CITY OF ALBUQUERQUE
PLANNING DEPARTMENT
DEVELOPMENT REVIEW BOARD

Project# 1008493

10DRB-70259 MAJOR – SITE DEVELOPMENT PLAN FOR BUILDING PERMIT

SLAGLE HERR ARCHITIECTS agent(s) for MECHENBIER CONSTRUCTION INC request(s) the referenced/ above action(s) for all or a portion of Lots 4 and 5, Block 3, Tract A, Unit B, **NORTH ALBUQUERQUE ACRES**, zoned IP, located on the south side of PASADENA AVE NE between SAN MATEO BLVD NE and PAN AMERICAN/ I-25 FREEWAY containing approximately 1.766 acres. (B-18)

Lot 5-A
 Being a Replat of
 Lots 4 & 5, Block 3
 Tract A, Unit B
 North Albuquerque Acres
 Elena Gallegos Grant
 Projected Section 13
 T.11N., R.3E. N.M.P.M.
 City of Albuquerque
 Bernalillo County, New Mexico
 October 2010

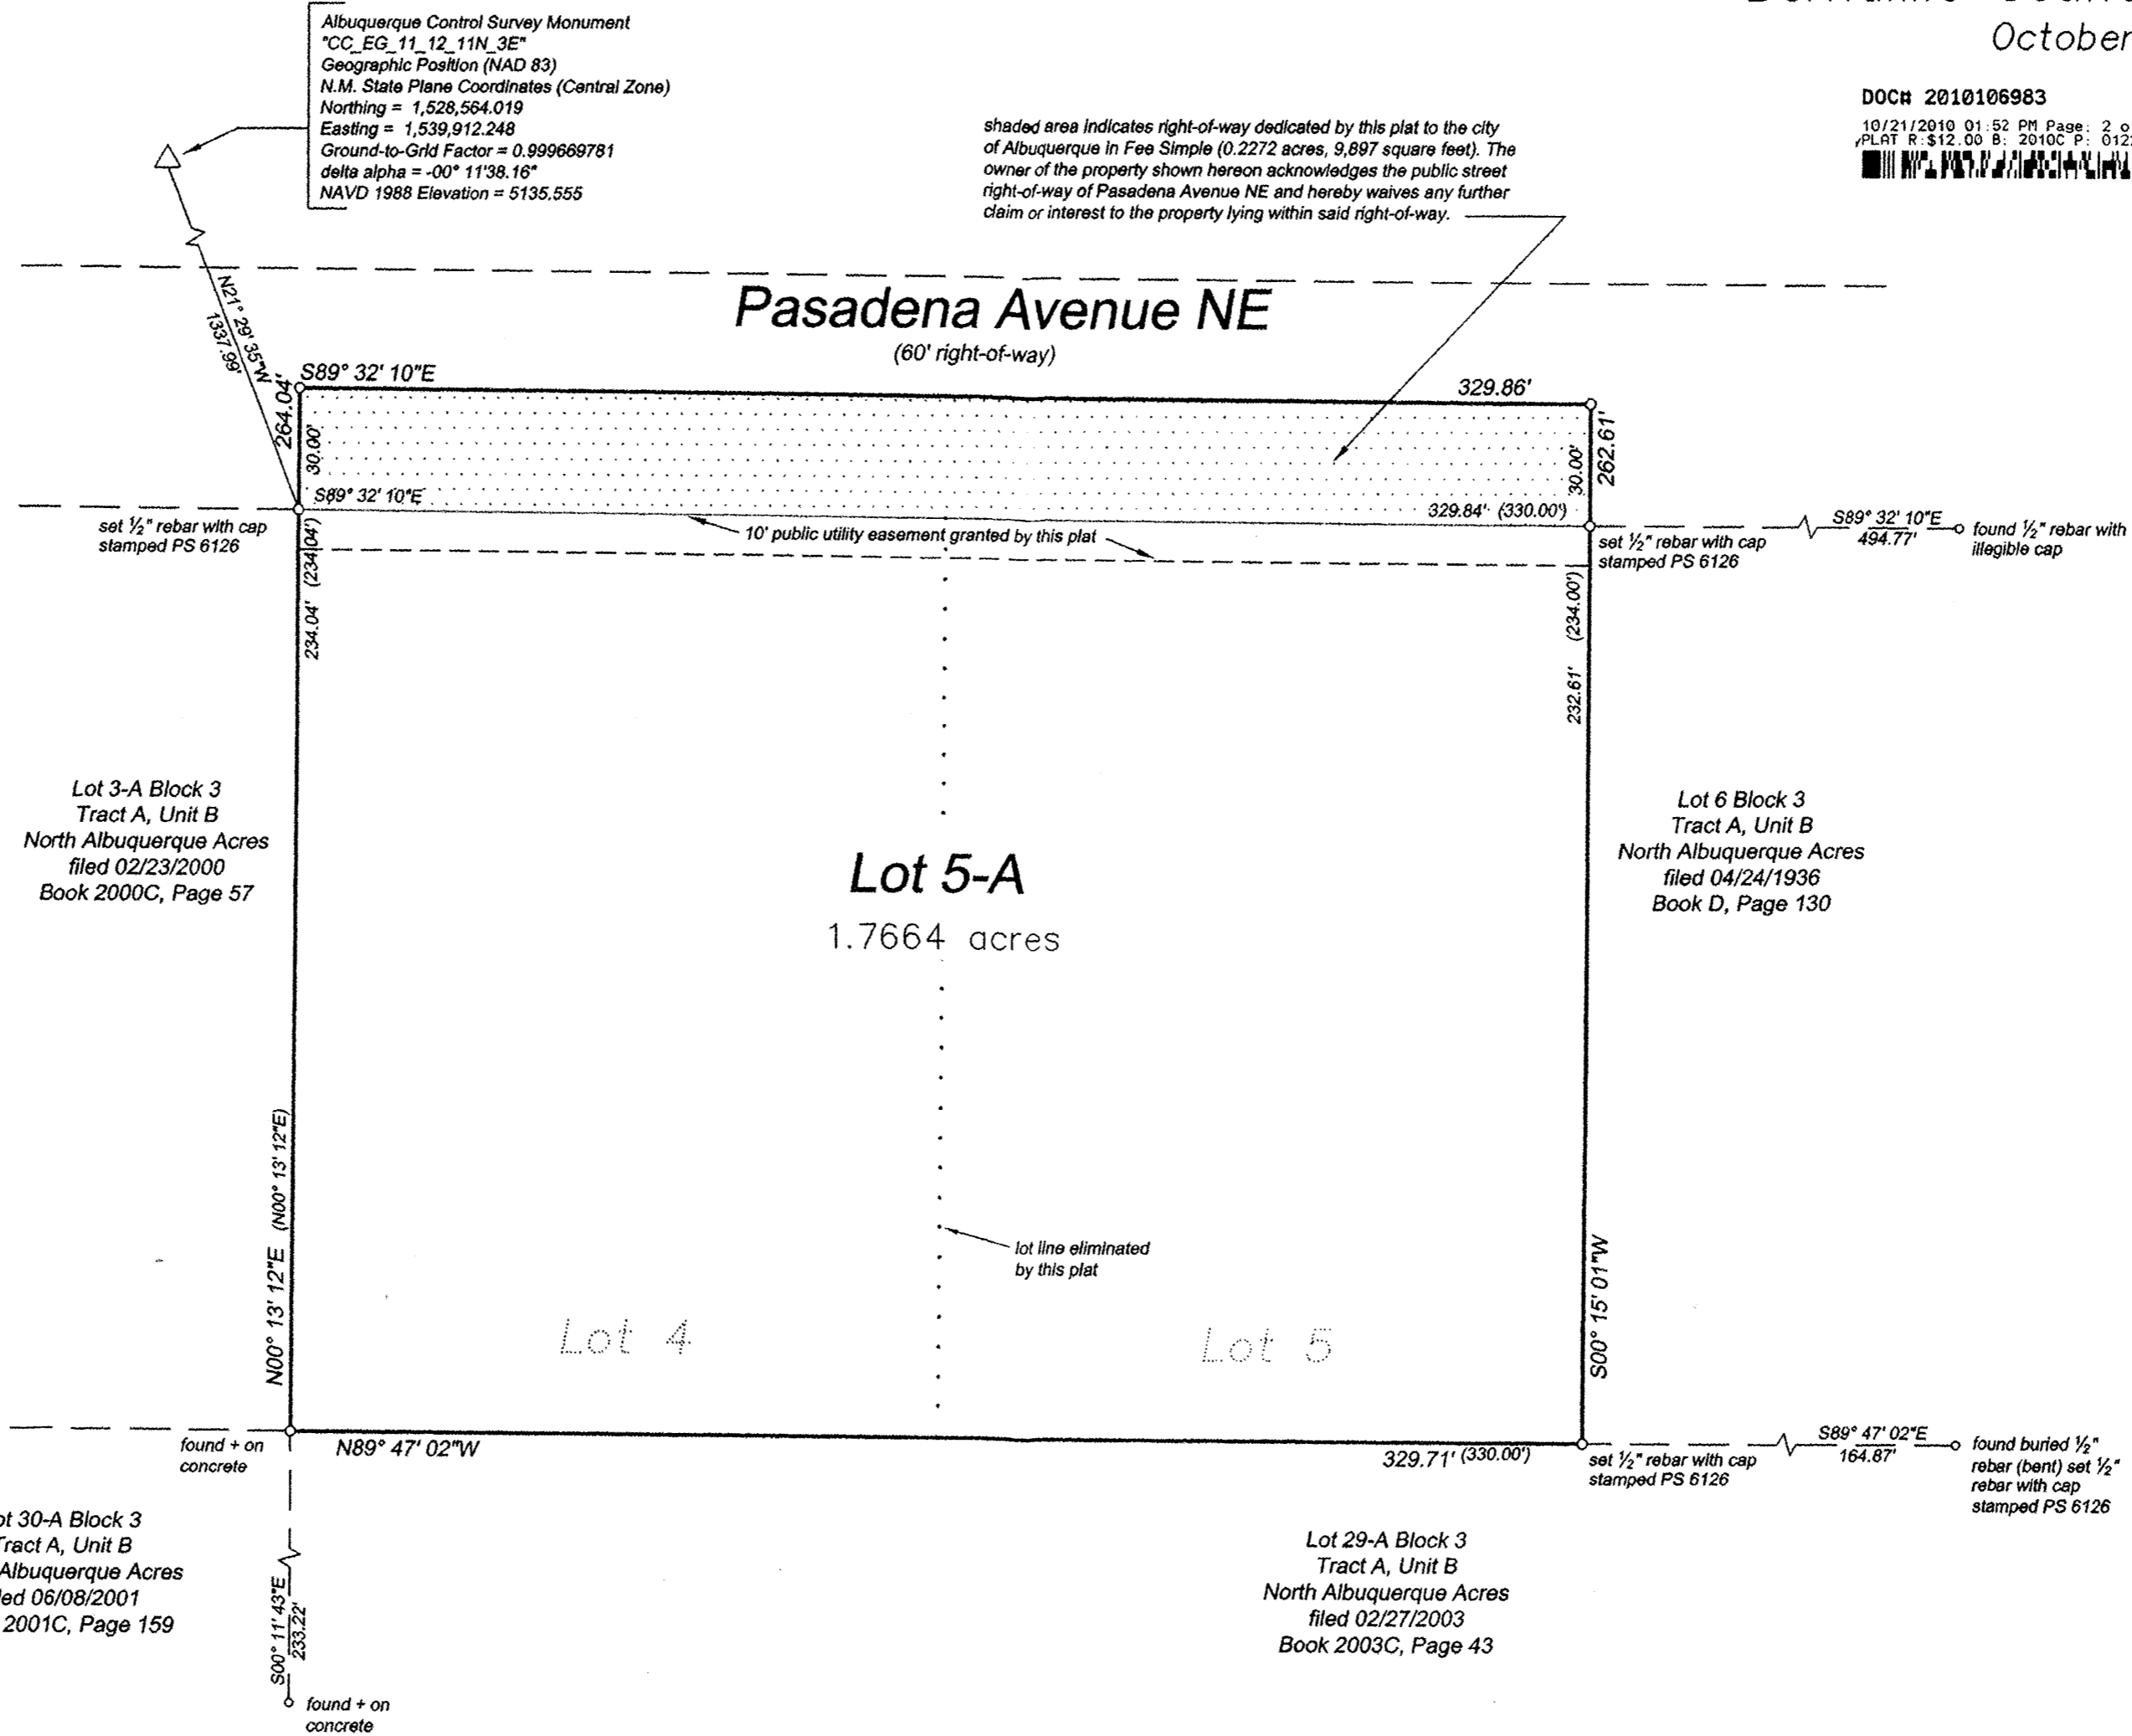
Proposed site plan will require a replat to consolidate the two lots into a single lot and to dedicated right-of-way for Pasadena Avenue.

LANDSCAPE PLAN

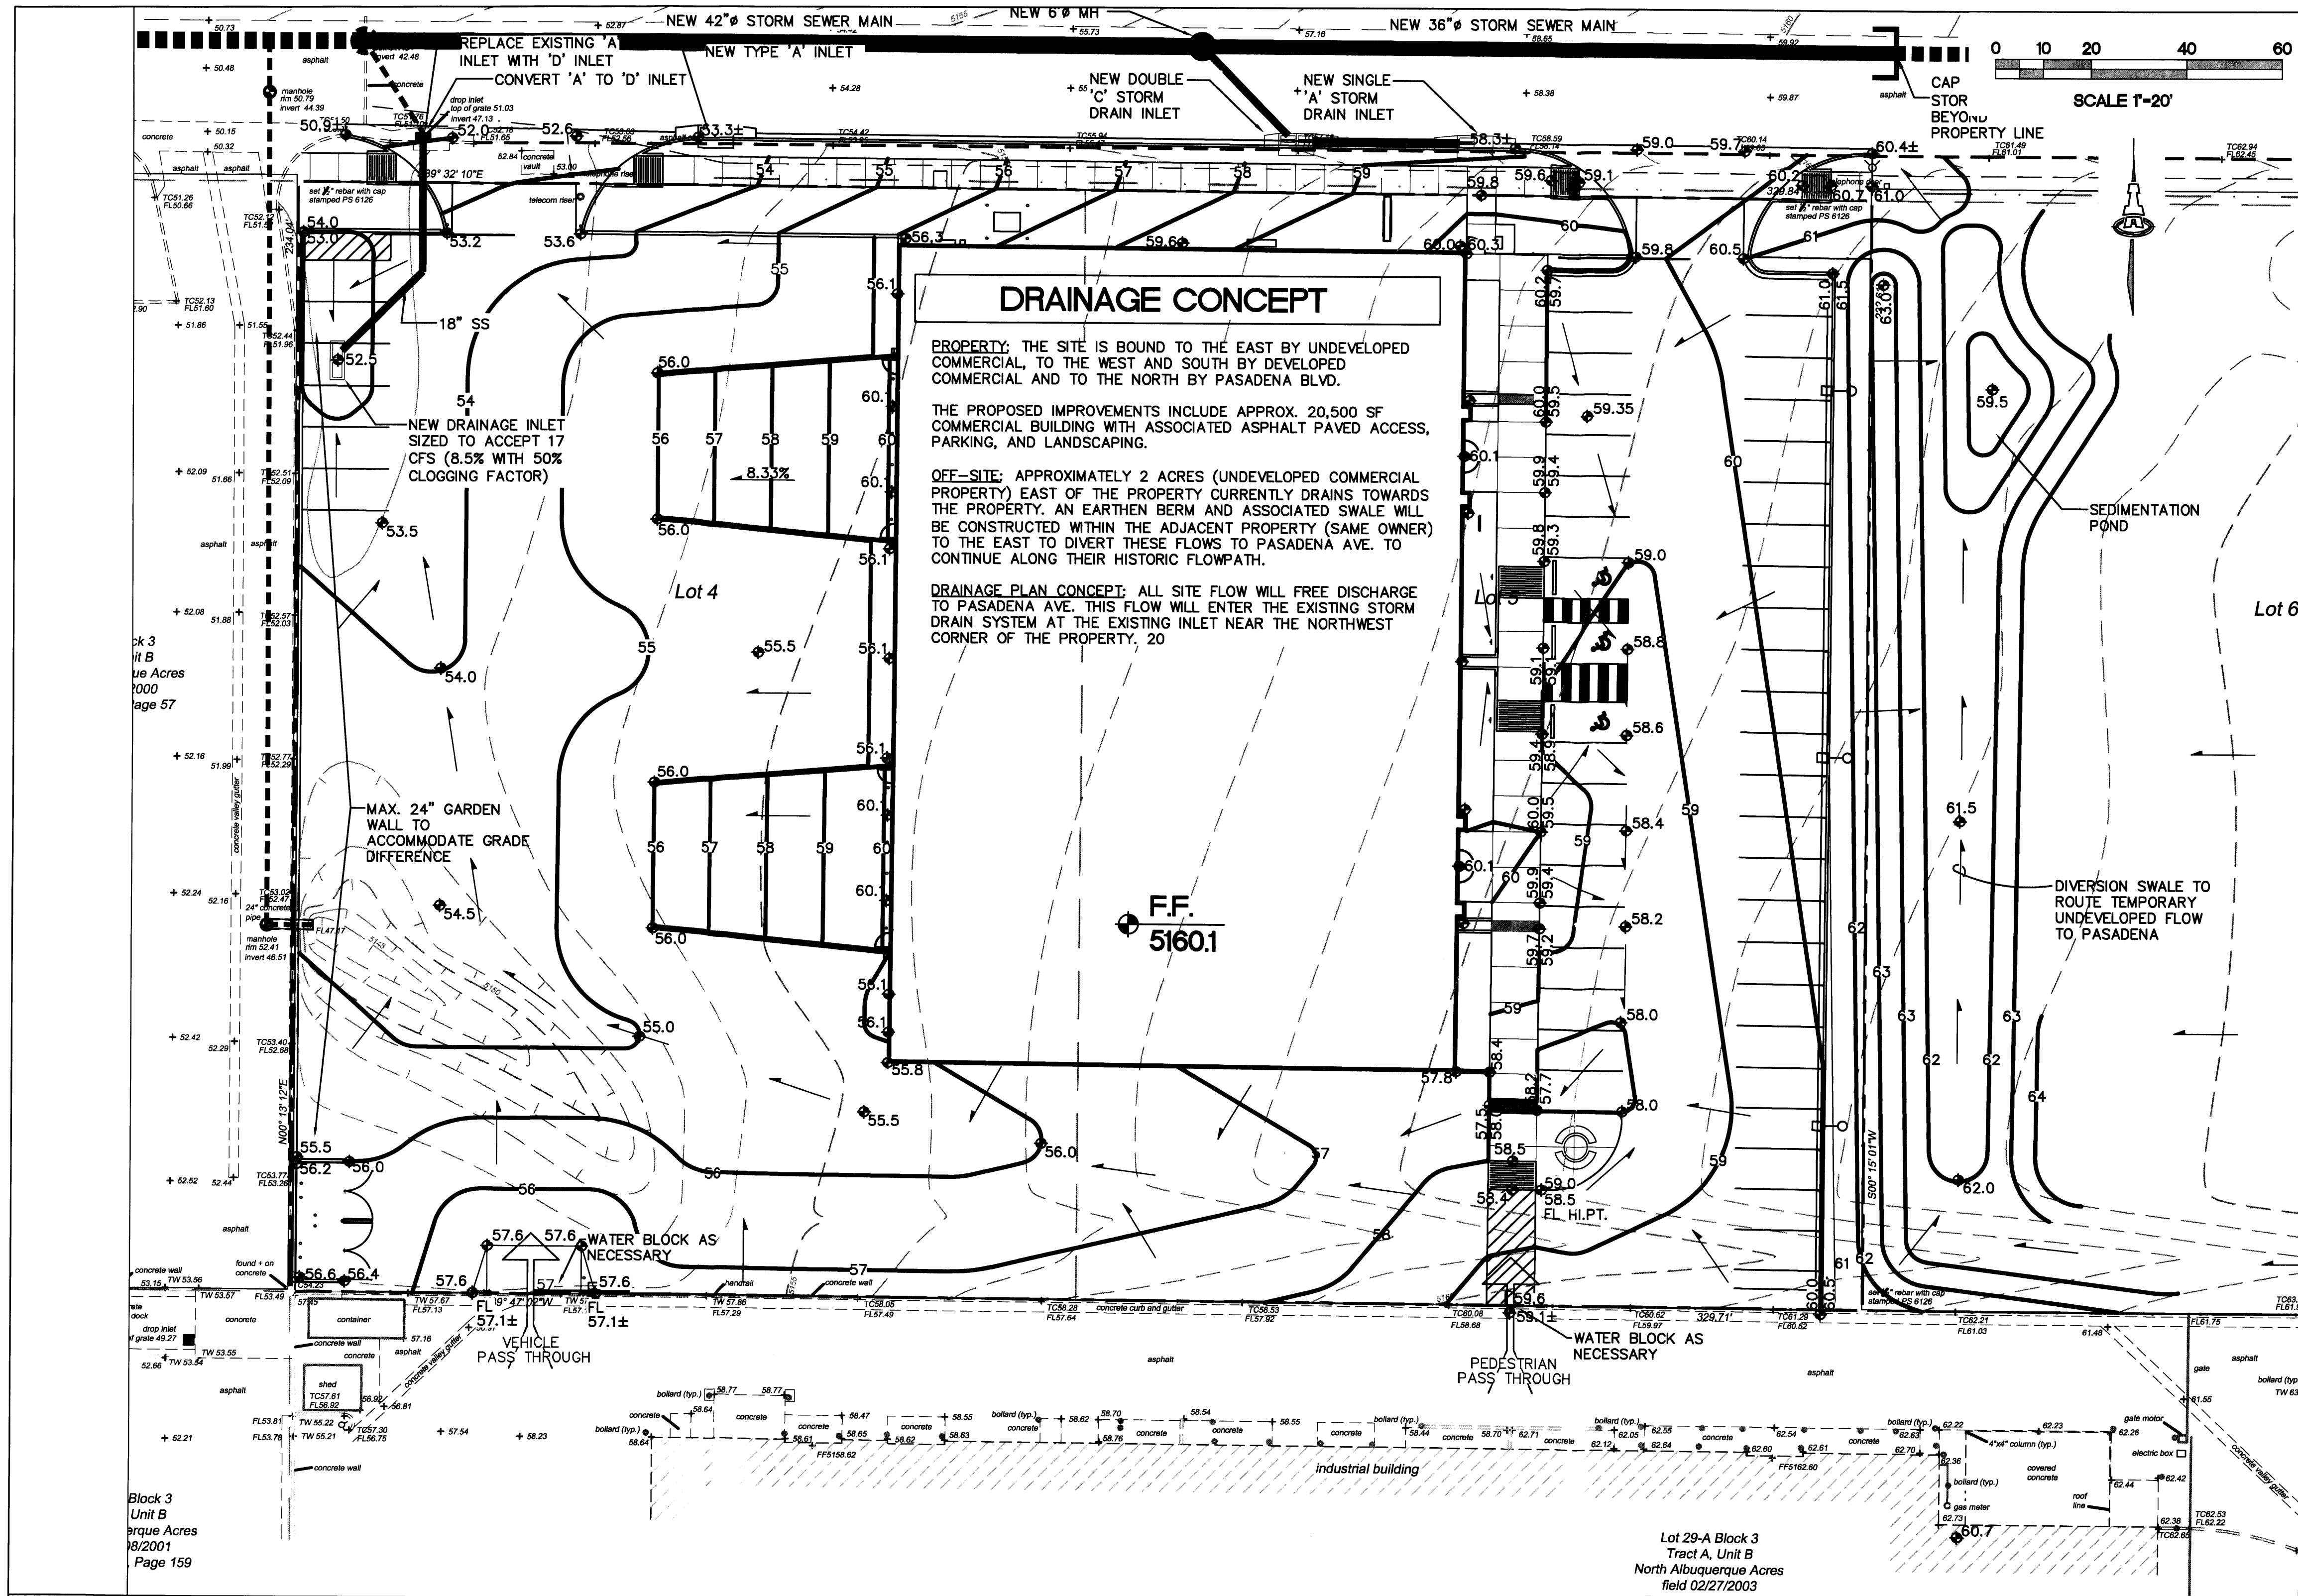
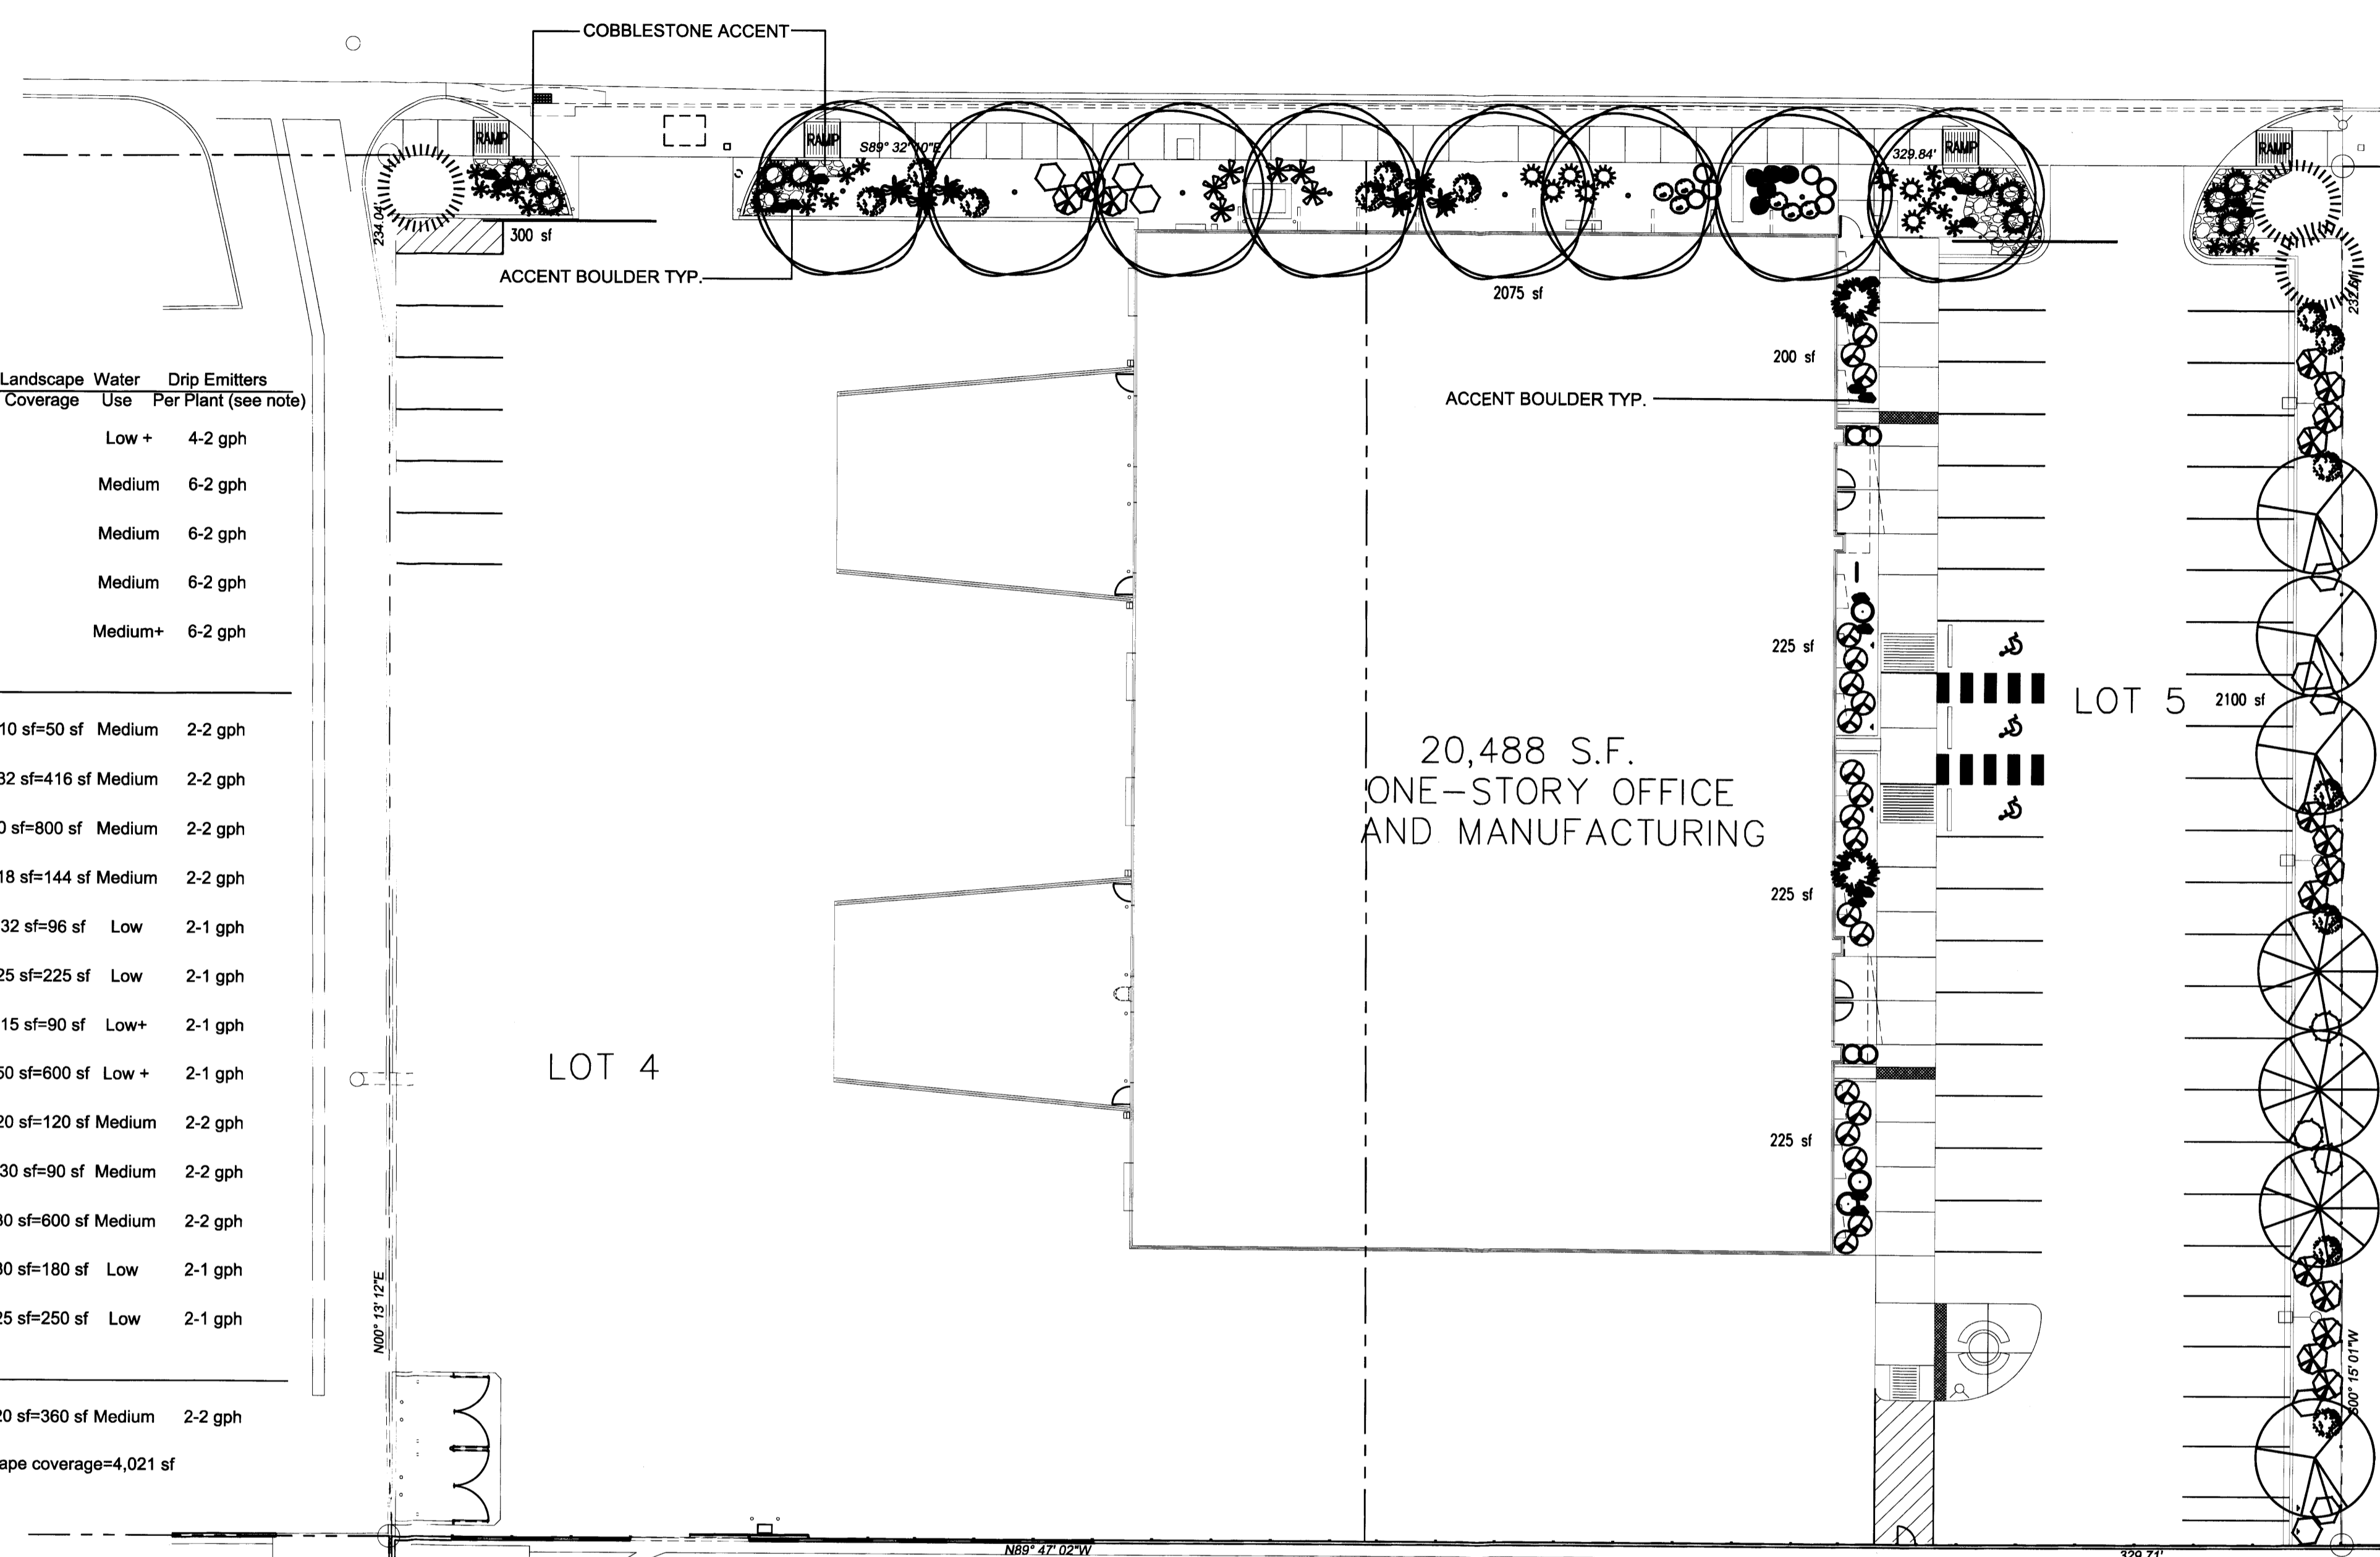
Landscaping must conform to Section 14-16-3-10 of Zoning Code – need six foot opaque wall or fence to qualify for “fully screened” exception for NET LOT AREA, and bufer landscaping is still required (six feet along west and south property lines per North I-25 Sector Plan).
